PLANNING APPLICATION CONSULTATION RESPONSE

Application Number:	3/2024/0710
Proposal:	Approval of details reserved by conditions 13 (SW drainage details), 14 (Constructions SW Management Plan) and 22 (levels) on planning permission 3/2022/0966.
Location:	Crow Trees Farm Crow Trees Brow Chatburn BB7 4AA

Lead Local Flood Authority Position

**Figure 3.1** Direction of runoff and potential location of temporary bunds and ditches

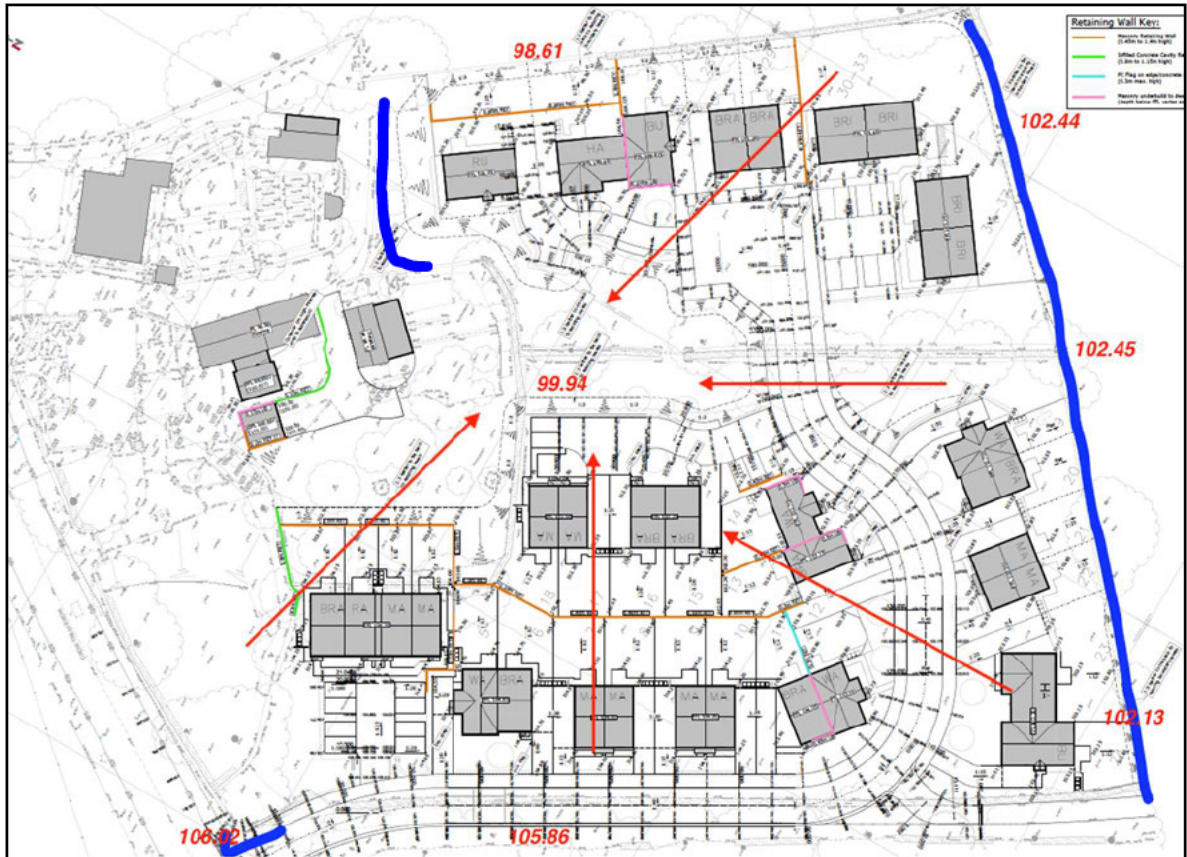
The Lead Local Flood Authority is currently **unable to recommend the discharge of condition 14** on planning decision 3/2022/0966 on the basis of:

- The applicant has failed to provide sufficient evidence to demonstrate that surface water will be retained onsite during the construction phase. The applicant is expected to provide further information to demonstrate that surface water will be retained onsite during construction prior to the surface water sustainable drainage

system being implemented. The applicant has stated that surface water during construction will be directed towards a centralised low (middle) point of the site, however the applicants evidence shows that the lowest point is in fact the north-eastern area of the development, and therefore surface water has the potential to flow offsite to the adjacent land. In addition to this, should surface water be directed to a central ponding area, the applicant has failed to provide evidence to demonstrate if this surface water is to be discharged from the site, how this will be achieved and at what rate.

- The applicant has failed to provide clear evidence of where pollution and siltation measures will be implemented onsite during the construction phase, taking into consideration the points outlined above and the boundary north-east of the development.
